Application for a Non-Material Amendment Following a Grant of Planning Permission

Land to the East of Shripney Road Shripney PO22 9NW

'outline application for up to 46 dwellings together with access, with all other matters reserved'.

BE/109/19/OUT and BE/61/23/RES

Detailed Planting Plan 1 of 3

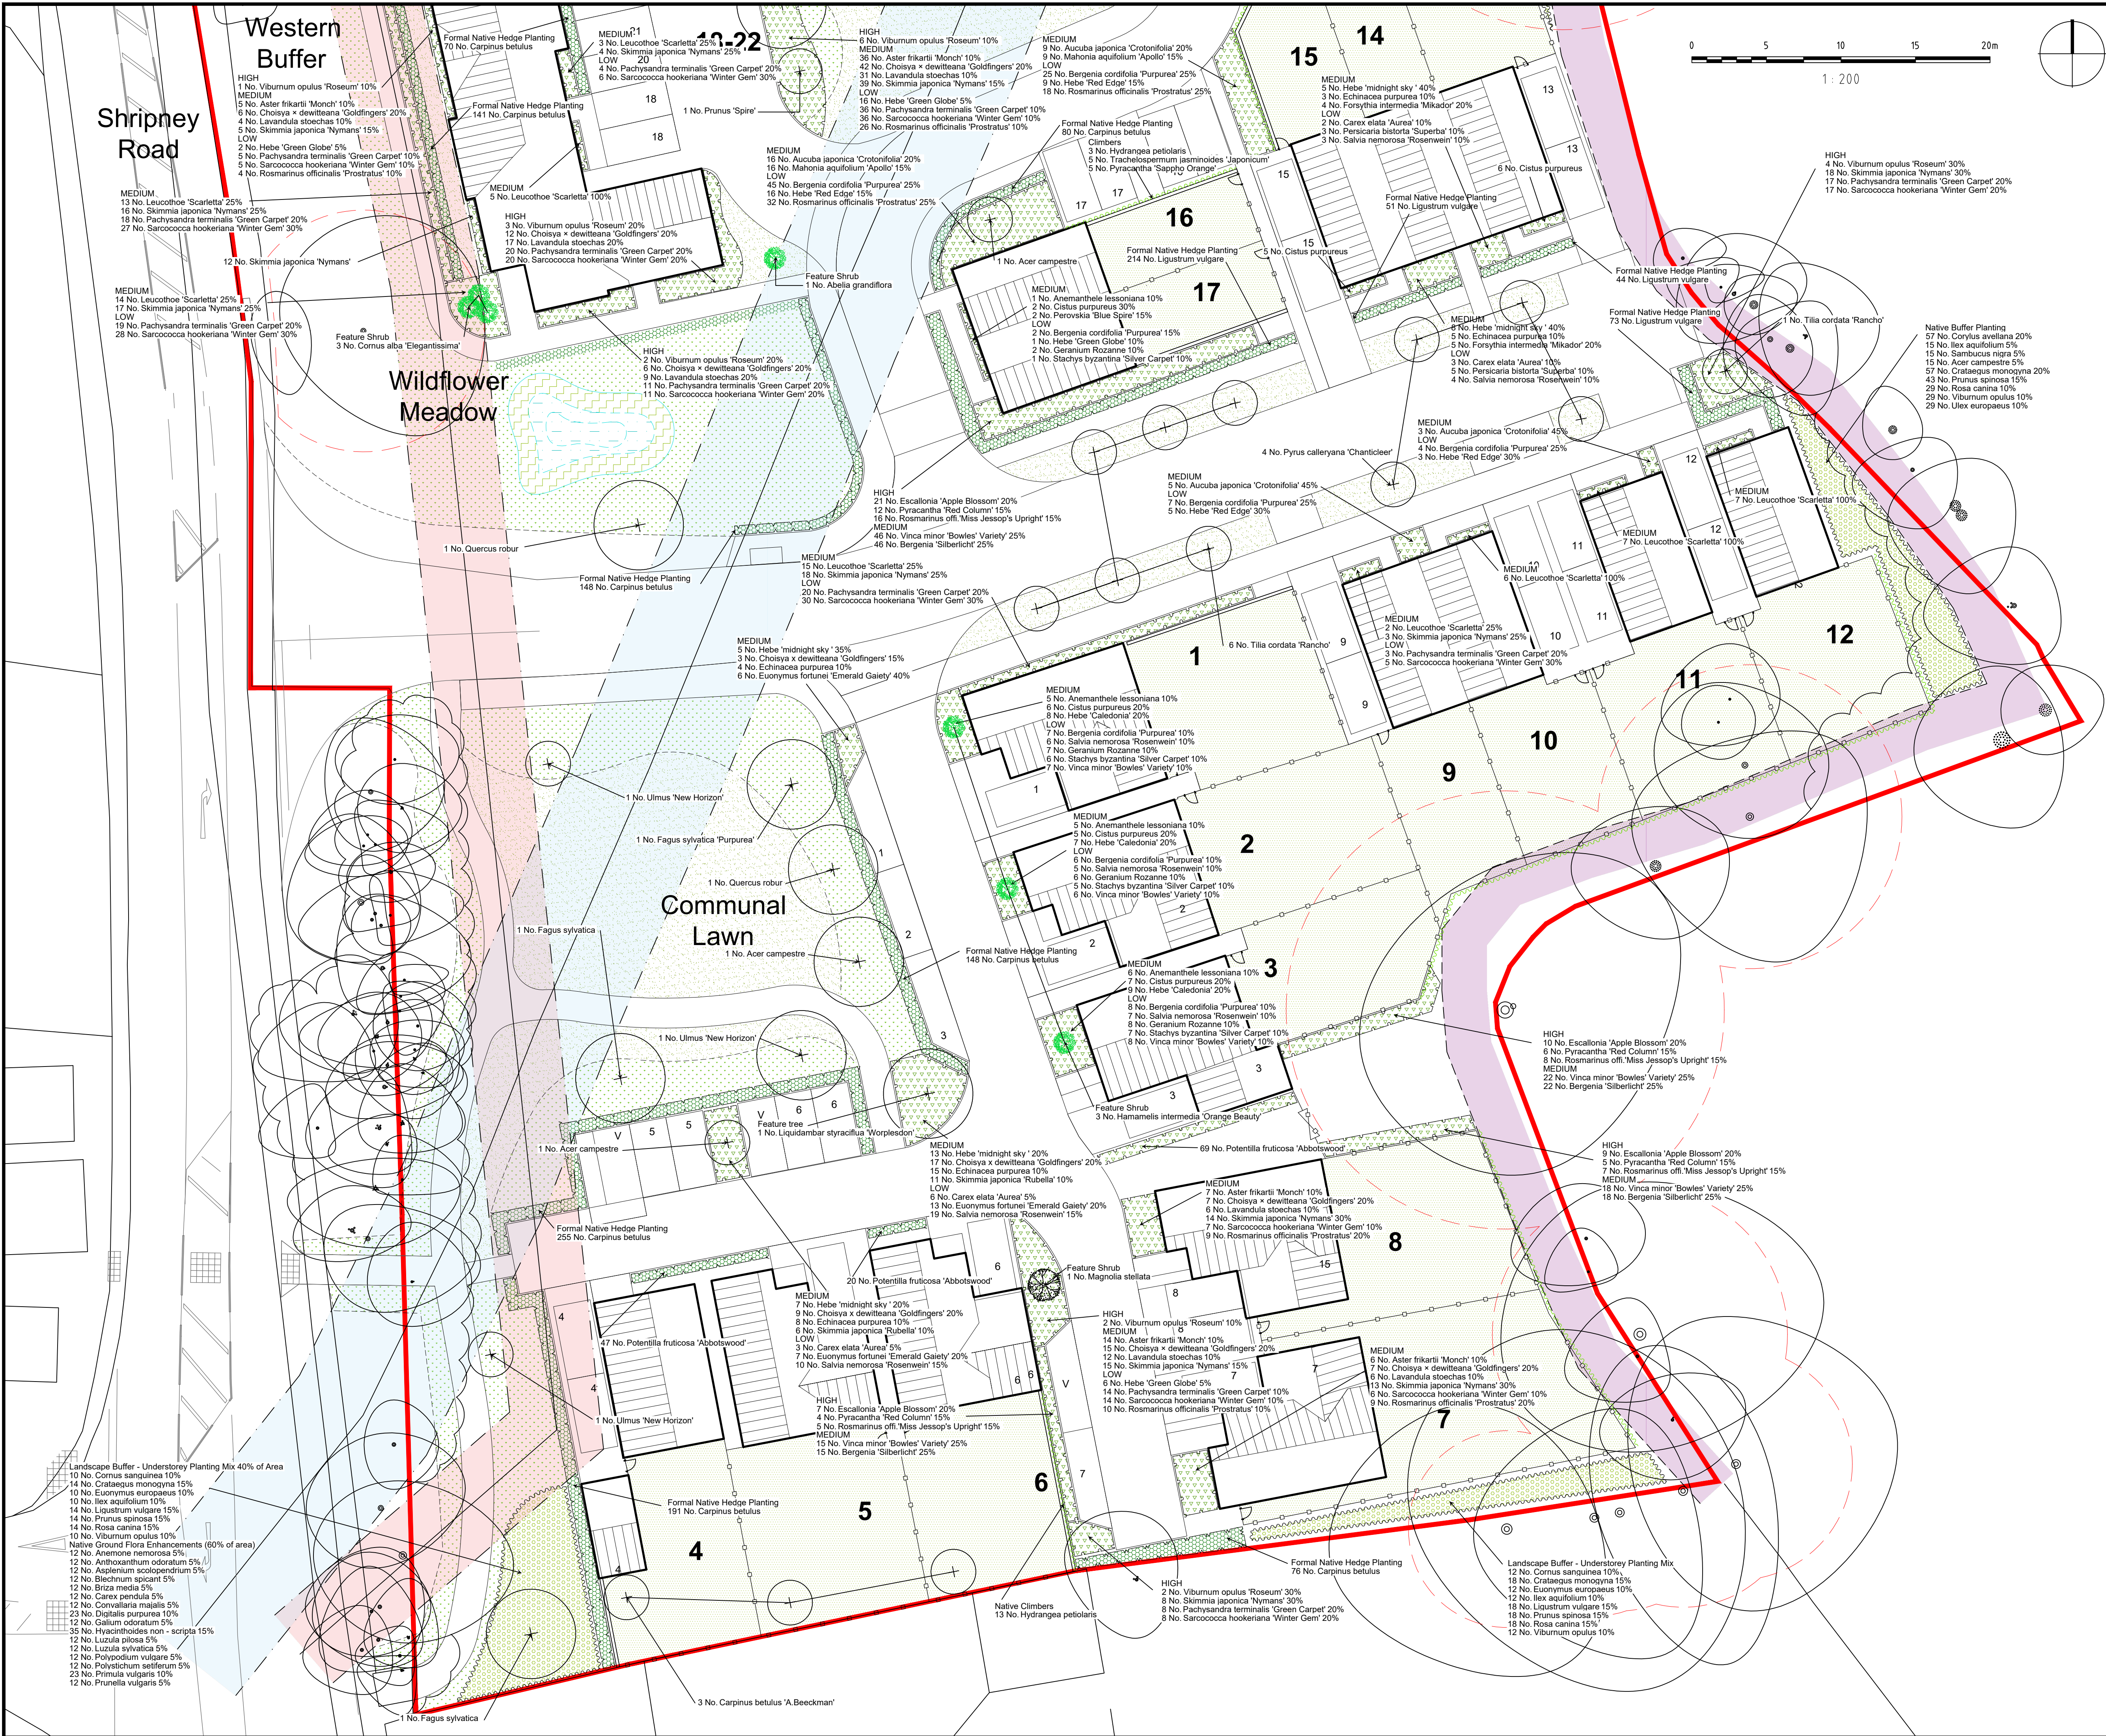
The proposed amendment relates to changing the specification of grass to the rear gardens of properties from 'Proposed lawn to back gardens – Naturescape N14 Flowering Lawn Mixture or similar' (as ap-proved) to 'Proposed amenity lawn to back gardens using high quality turf - Rowlan Medallion or similar' (as proposed).

This proposed change is at the request of Aster Homes (Housing Association), with whom we are currently in contract for the sale of all 44 plots on the site. A flowering lawn mixture in rear gardens creates mainte-nance issues for the homeowners, and hence a more typical turfed amenity lawn is preferred.

- DD598L03 Rev C Detailed Planting Plan 1 of 3
- DD598L04 Rev C Detailed Planting Plan 2 of 3
